APPLICATION FOR A NON MATERIAL AMENDMENT UNDER SECTION 96A OF THE TOWN AND COUNTRY PLANNING ACT (1990) ACT TO REF. 75111/APP/2022/1007 WITH REGARDS TO:

- **ENERGY CENTRE 2**
- **ENERGY CENTRE 3**
- **VISITOR RECEPETION CENTRE 1**

LAND AT BULLS BRIDGE INDUSTRIAL ESTATE, NORTH HYDE GARDENS, HAYES, UB3 4QQ

EC2 Floor Plans & Top View

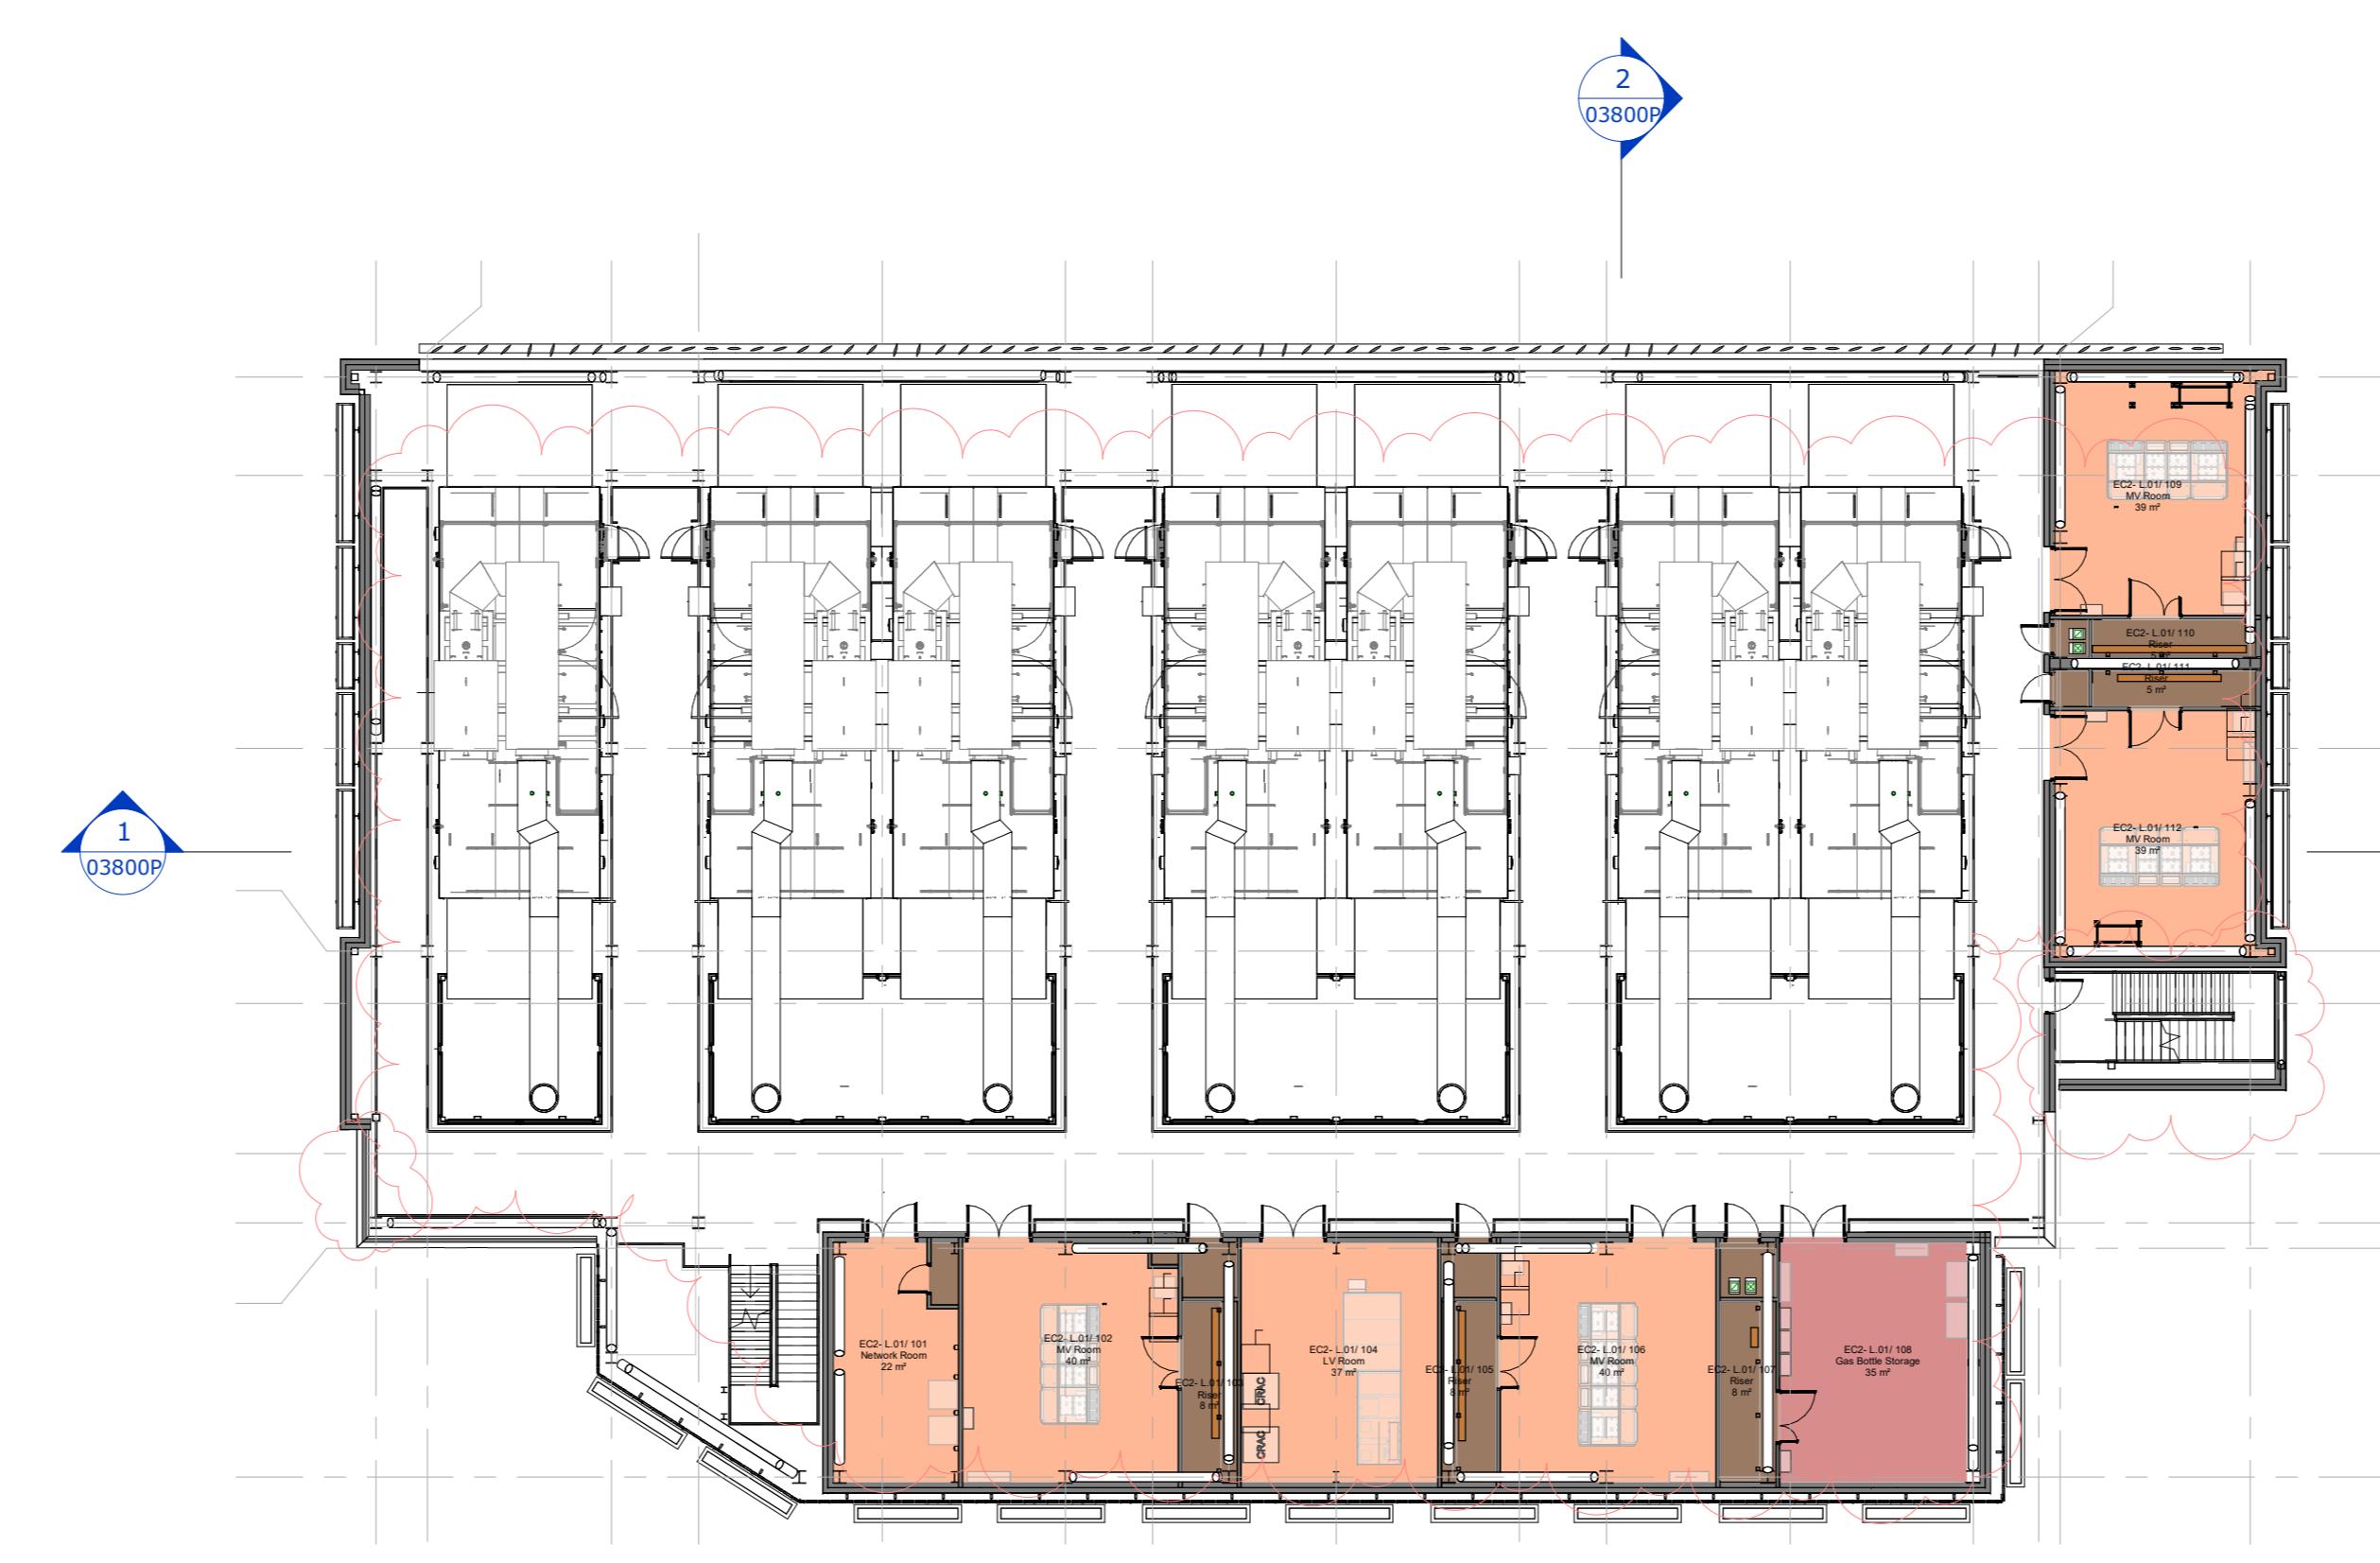
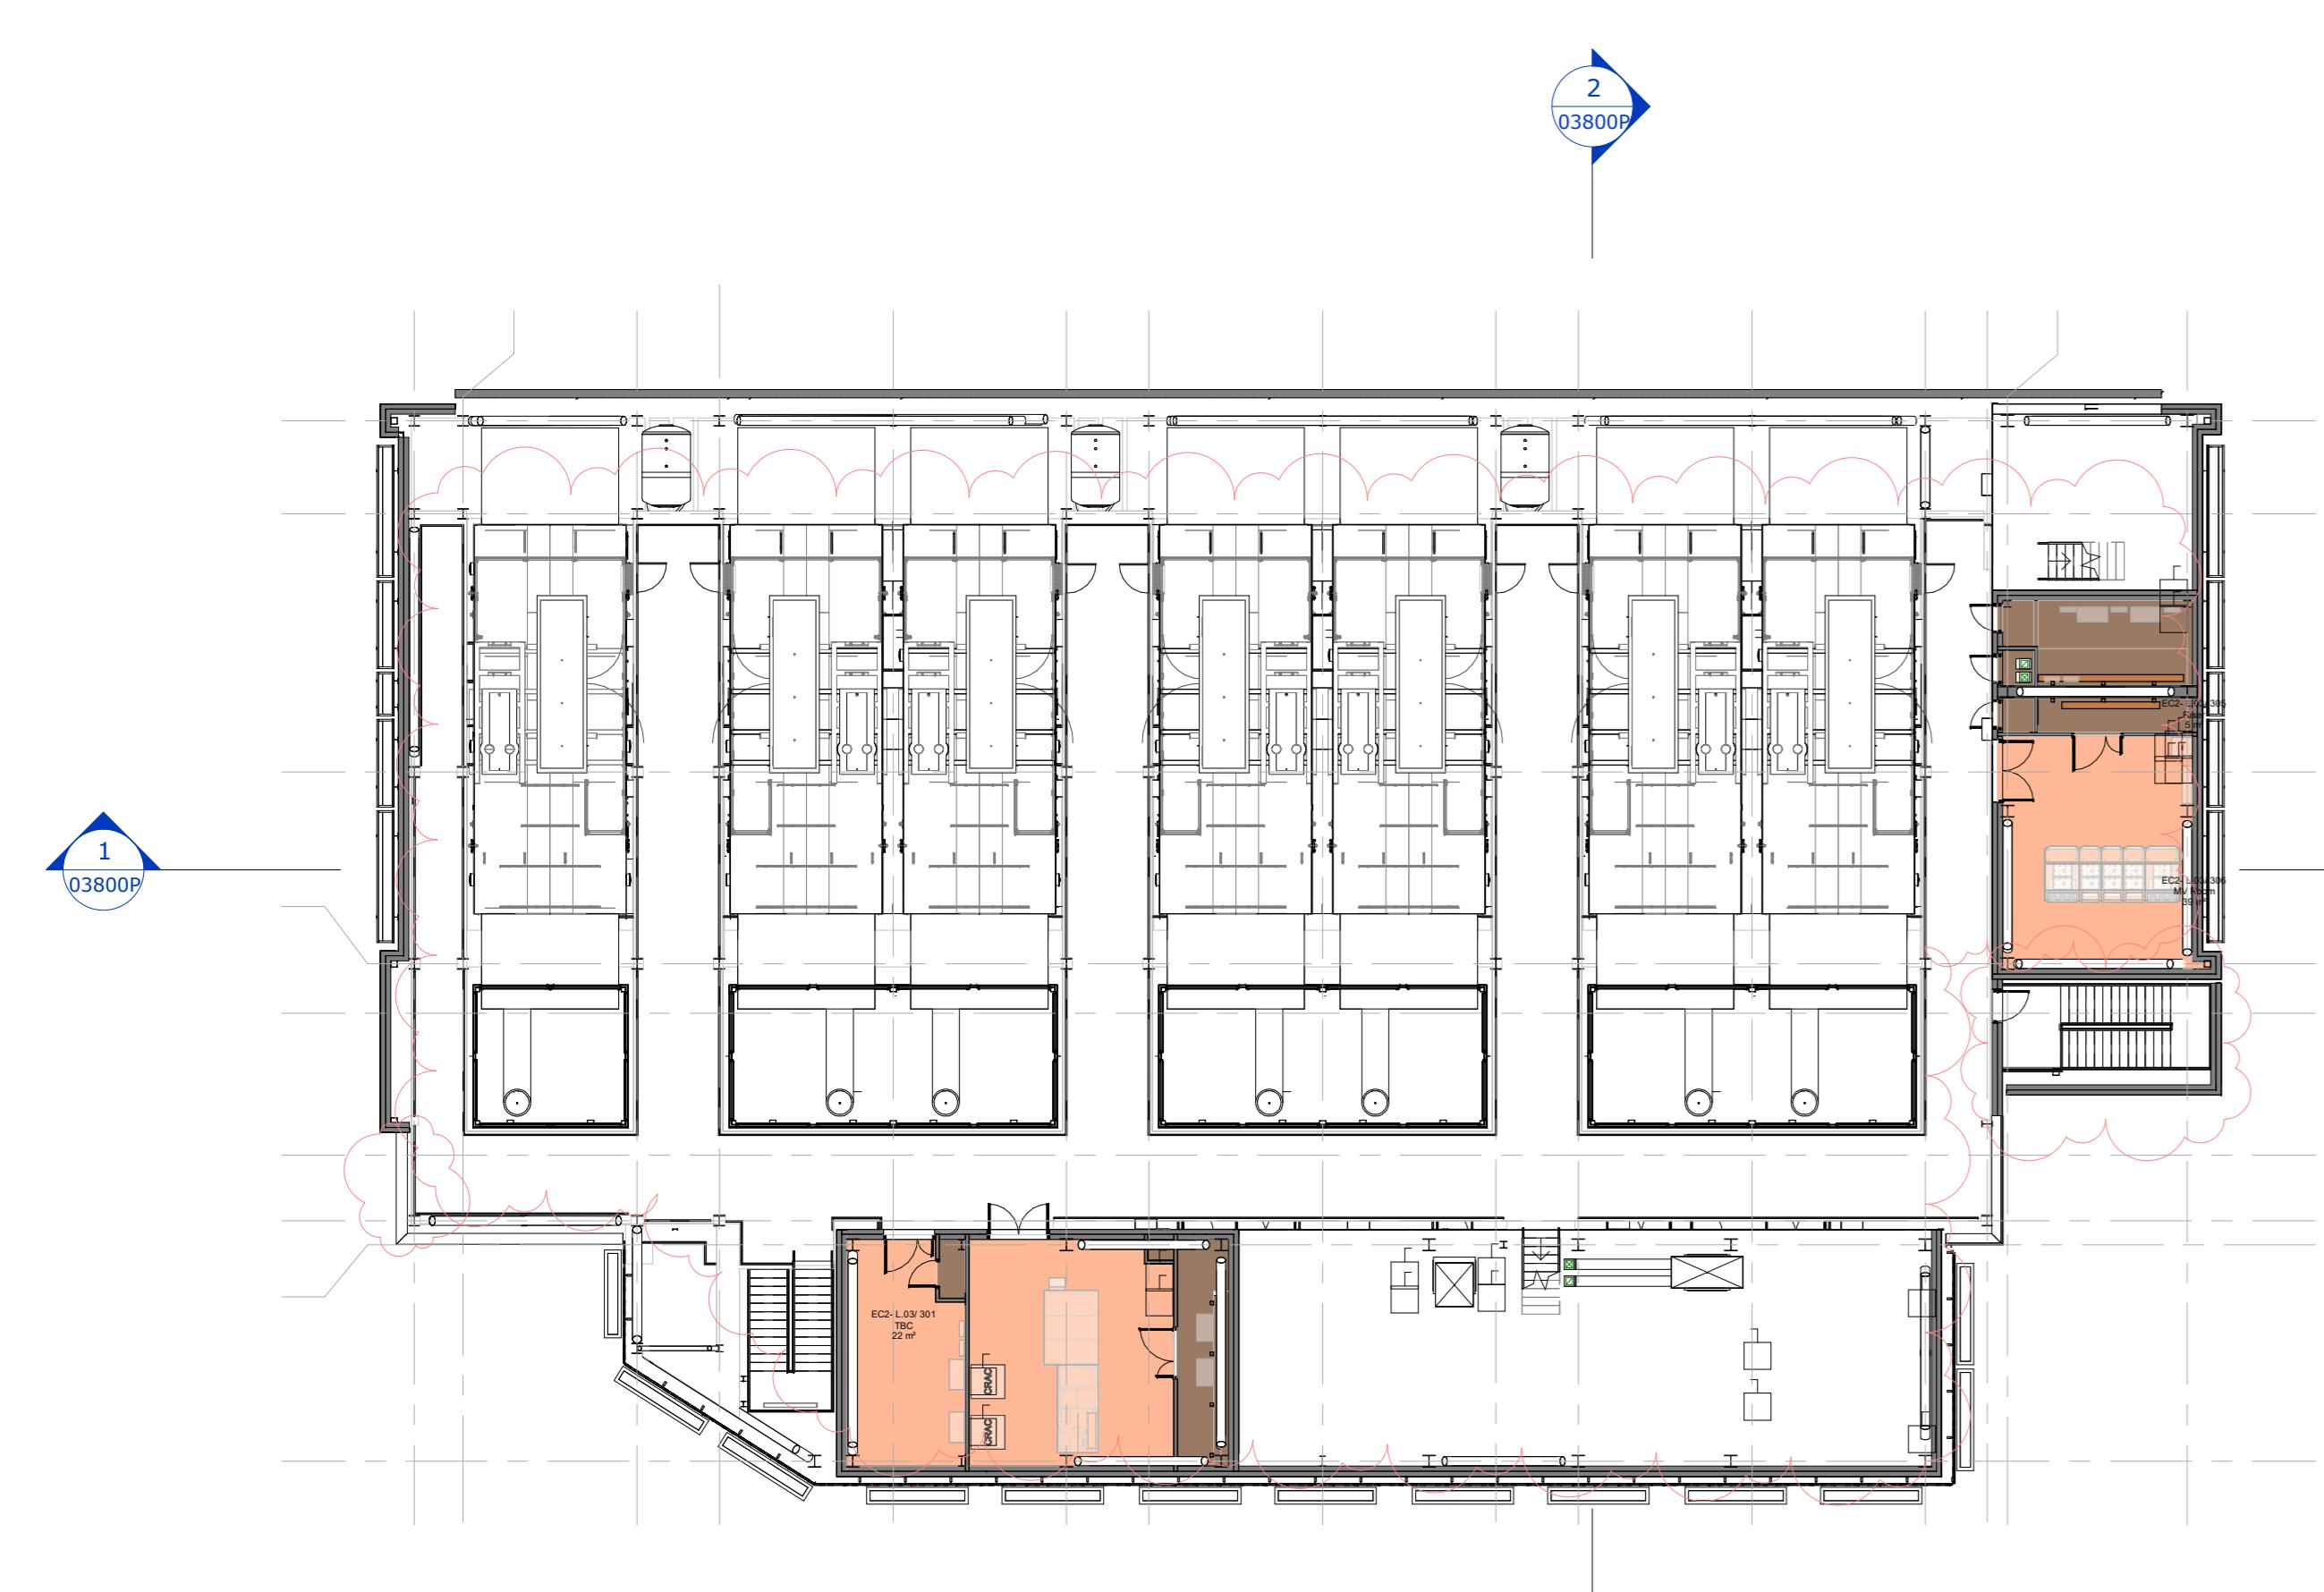
- Installation of an additional staircase at the southeastern corner of the building. This will be clad in the same materials as the wider building;
- Modest refinement of the footprint of Energy Centre 2 along its western and southern boundary. As shown on the plans submitted, these changes are modest in the extreme and could reasonably be considered to be de minimis;

- To facilitate plant replacement, there is a requirement for the replacement of the brickwork along the northern elevation of Energy Centre 2 with louvres and the replacement of landscaping with planters to facilitate access;

- Reconfiguration of the green wall arrangement along the building's southern and western elevations. Importantly, the quantum of green walling (and the urban greening factor that is achieved) remains unchanged; and

- Reconfiguration of the building's internal arrangement which will mean that the heat rejection stacks will no longer be visible.
